Subject: Rezoning Petition Review

Rezoning Petition #: 21-201

Location of Property: Approximately 1.15 acres located in the northwest quadrant of the intersection of Weddington Ave and Bascom St, east of E 7th St.

SHEET NAME
REZONING SITE PLAN

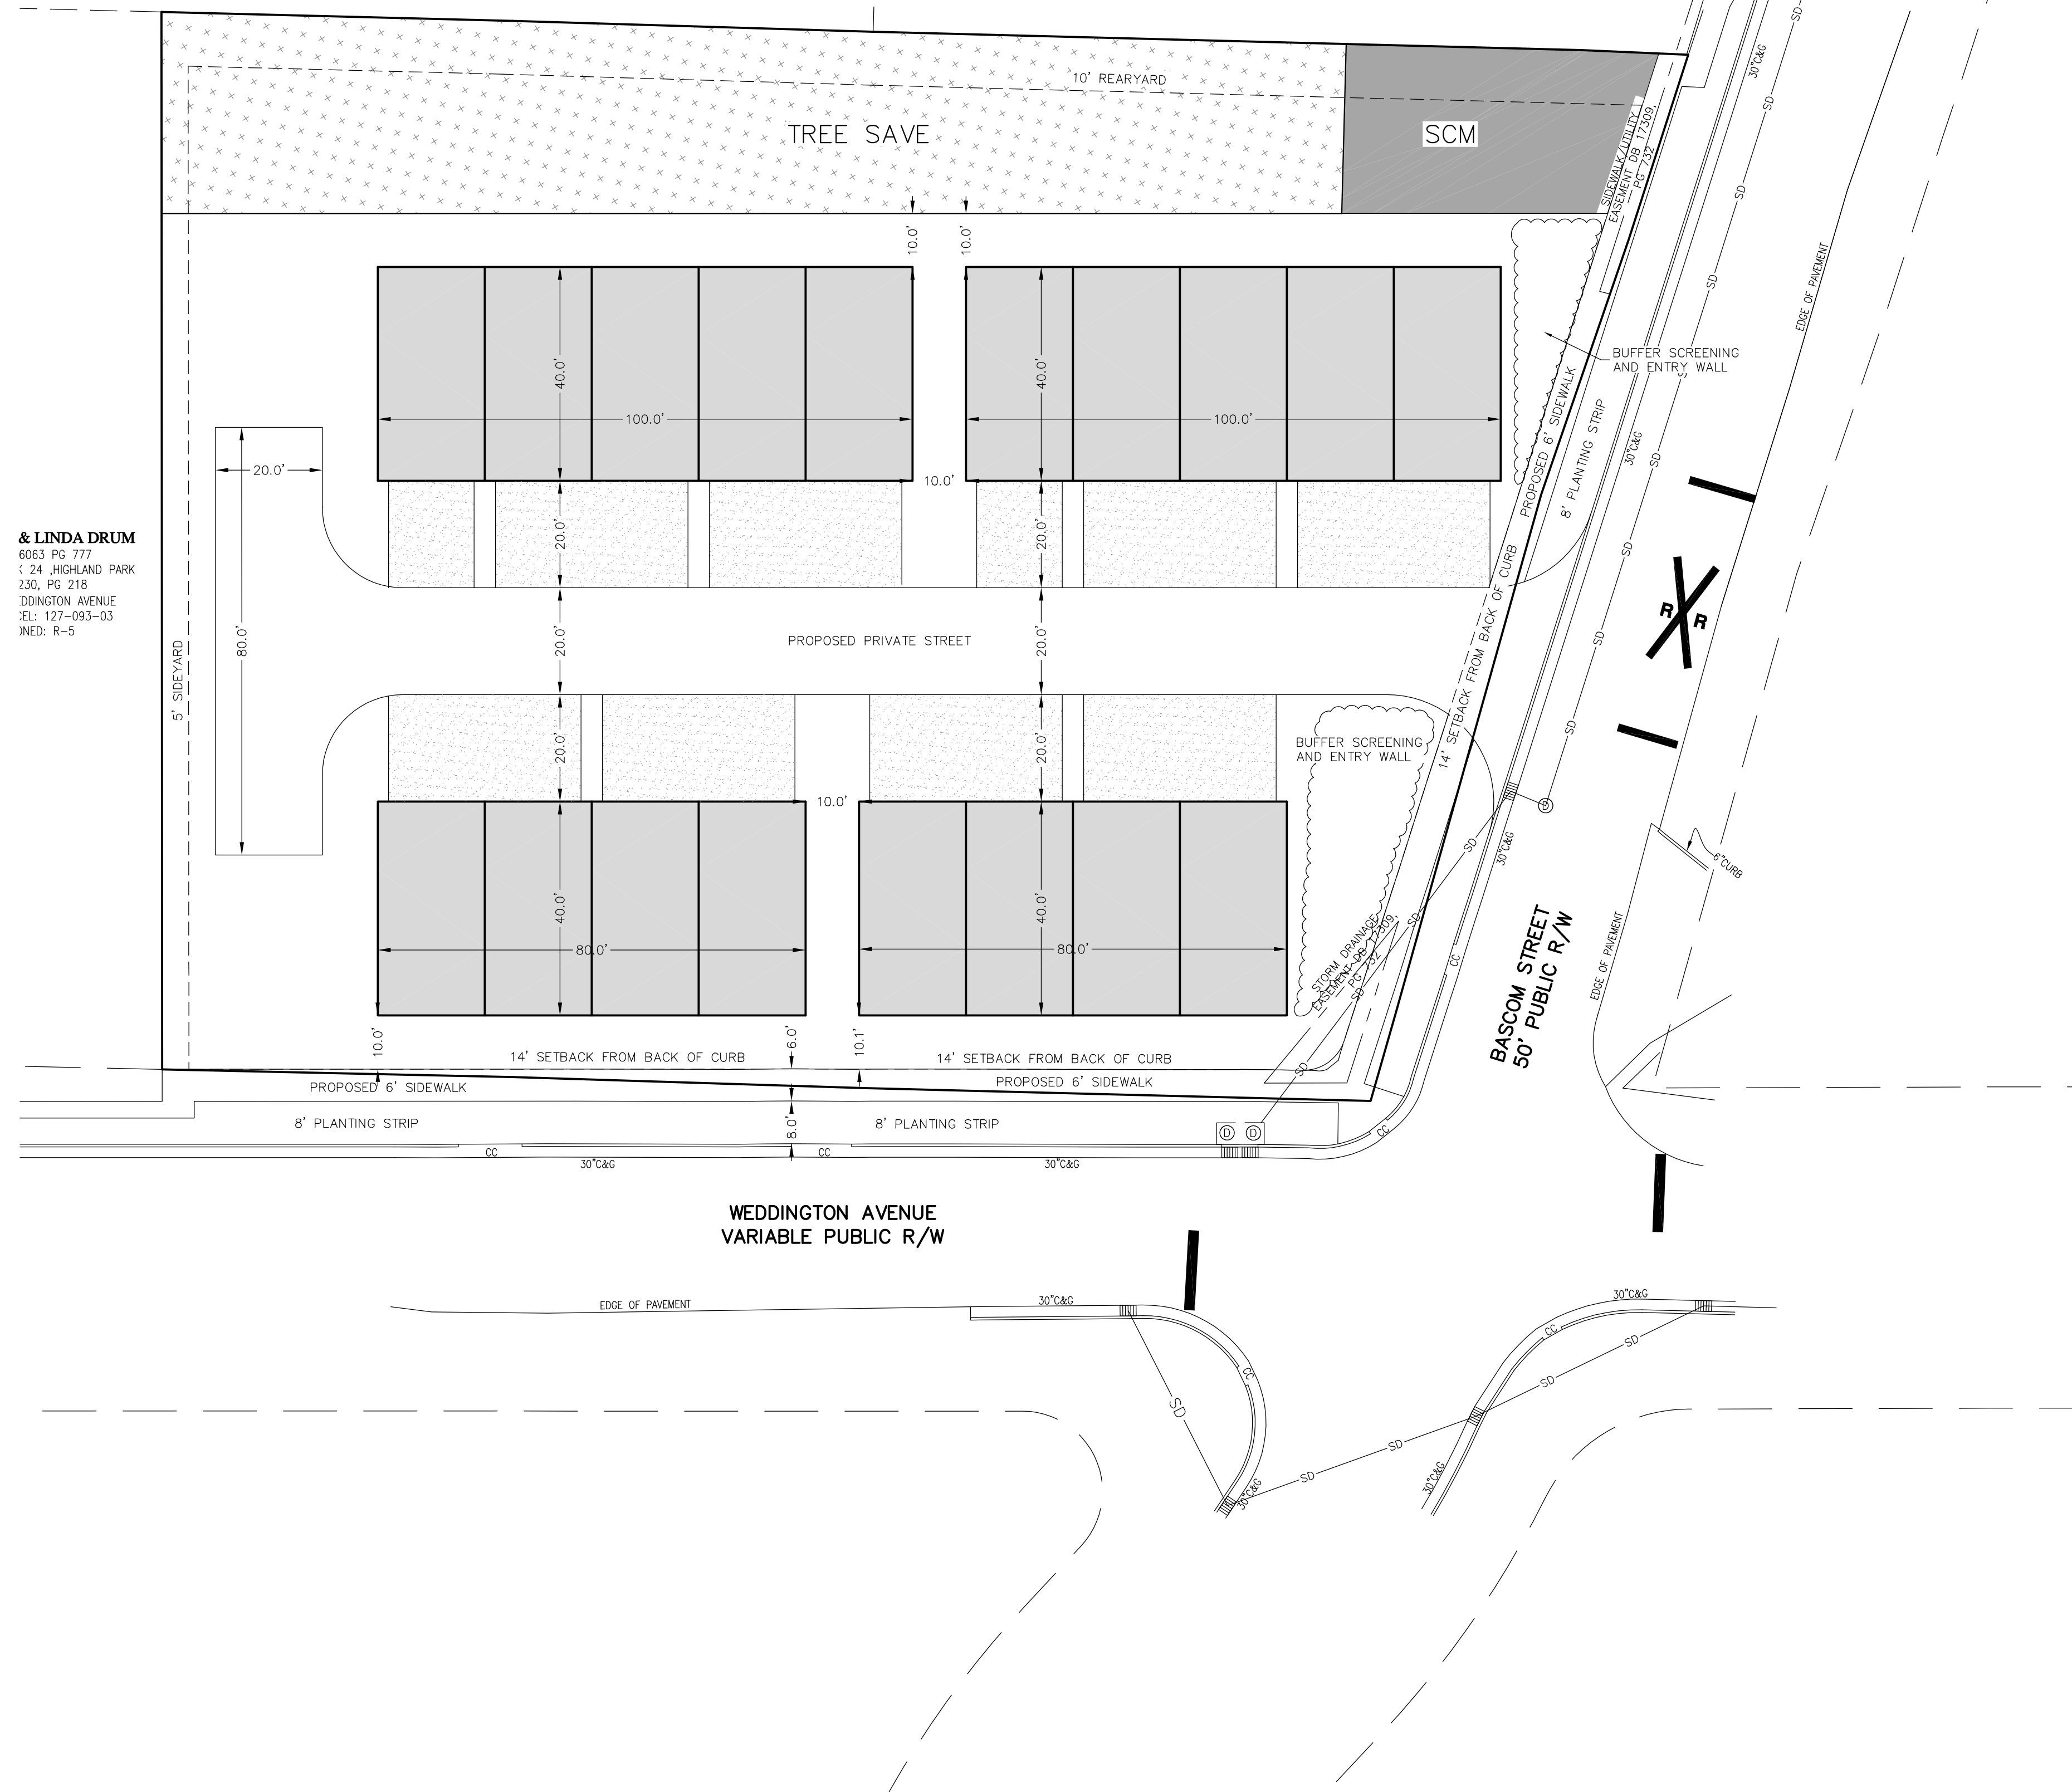
The proposed rezoning plan sheet indicates a proposed location for storm water management. Please include the following notes on the plan sheet under "Environmental Features": *The location, size, and type of storm water management systems depicted on the Rezoning Plan are subject to review and approval as part of the full development plan submittal and are not implicitly approved with this rezoning. Adjustments may be necessary in order to accommodate actual storm water treatment requirements and natural site discharge points.*

This property drains to Briar Creek, which is an impaired/degraded stream, and may contribute to downstream flooding. This project has the opportunity to mitigate future impacts to this stream, therefore, Storm Water recommends placing the following notes on the plan:

(I) Storm Water Quality Treatment

For defined watersheds greater than 24% built-upon area (BUA), construct water quality stormwater control measures (SCMs) designed for the runoff generated from the first 1-inch of rainfall for all new and redeveloped BUA associated with the project. SCMs must be designed and constructed in accordance with the Charlotte-Mecklenburg BMP Design Manual.

(II) Volume and Peak Control

For defined watersheds greater than 24% built-upon area, control the entire volume for the 1-year, 24-hour storm for all new and redeveloped BUA associated with the project. Runoff volume drawdown time shall be in accordance with the Charlotte-Mecklenburg BMP Design Manual.

For commercial projects with greater than 24% BUA, control the peak to not exceed the predevelopment runoff rates for the 10-yr, 6-hr storm and perform a downstream flood analysis to determine whether additional peak control is needed and if so, for what level of storm frequency, or if a downstream analysis is not performed, control the peak for the 10-yr and 25-yr, 6-hour storms.

For residential projects with greater than 24% BUA, control the peak to not exceed the predevelopment runoff rates for the 10-year and 25-year, 6-hour storms or perform a downstream analysis to determine whether peak control is needed, and if so, for what level of storm frequency.

SHEET NAME
REZONING SITE PLAN

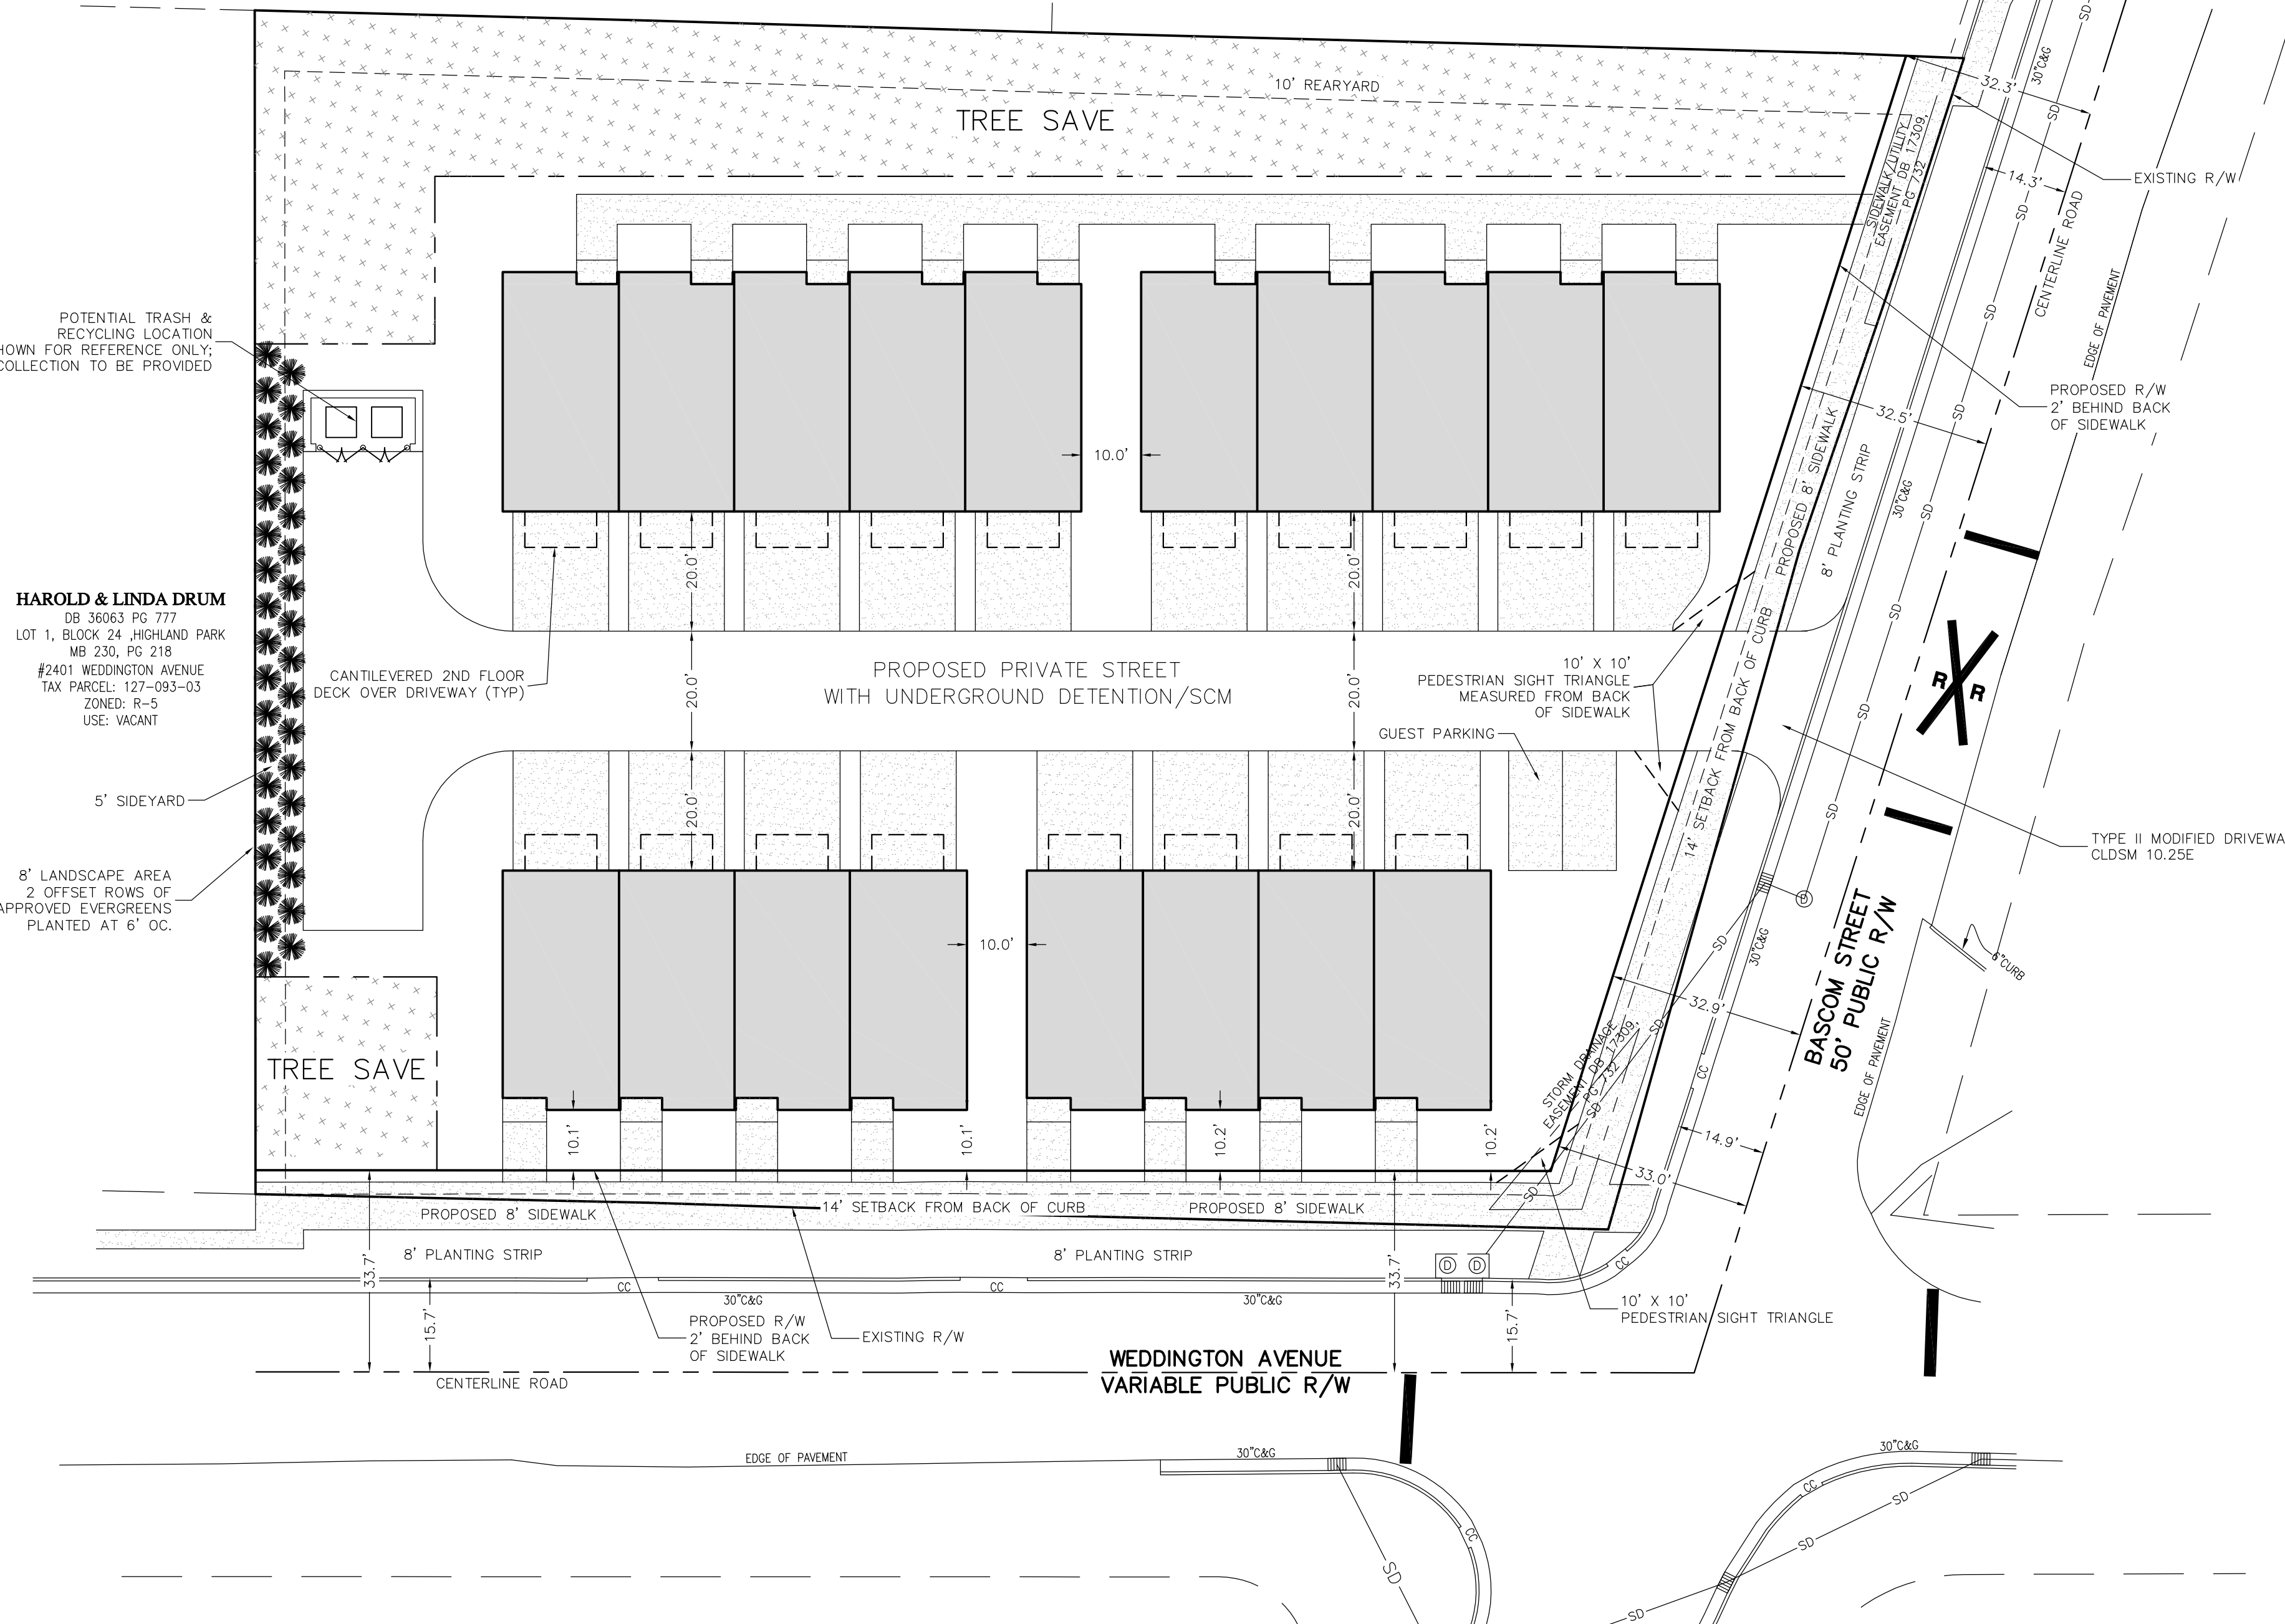
This property drains to Briar Creek, which is an impaired/degraded stream, and may contribute to downstream flooding. This project has the opportunity to mitigate future impacts to this stream, therefore, Storm Water recommends placing the following notes on the plan:

(I) Storm Water Quality Treatment

For defined watersheds greater than 24% built-upon area (BUA), construct water quality stormwater control measures (SCMs) designed for the runoff generated from the first 1-inch of rainfall for all new and redeveloped BUA associated with the project. SCMs must be designed and constructed in accordance with the Charlotte-Mecklenburg BMP Design Manual.

(II) Volume and Peak Control

For defined watersheds greater than 24% built-upon area, control the entire volume for the 1-year, 24-hour storm for all new and redeveloped BUA associated with the project. Runoff volume drawdown time shall be in accordance with the Charlotte-Mecklenburg BMP Design Manual.

For commercial projects with greater than 24% BUA, control the peak to not exceed the predevelopment runoff rates for the 10-yr, 6-hr storm and perform a downstream flood analysis to determine whether additional peak control is needed and if so, for what level of storm frequency, or if a downstream analysis is not performed, control the peak for the 10-yr and 25-yr, 6-hour storms.

For residential projects with greater than 24% BUA, control the peak to not exceed the predevelopment runoff rates for the 10-year and 25-year, 6-hour storms or perform a downstream analysis to determine whether peak control is needed, and if so, for what level of storm frequency.
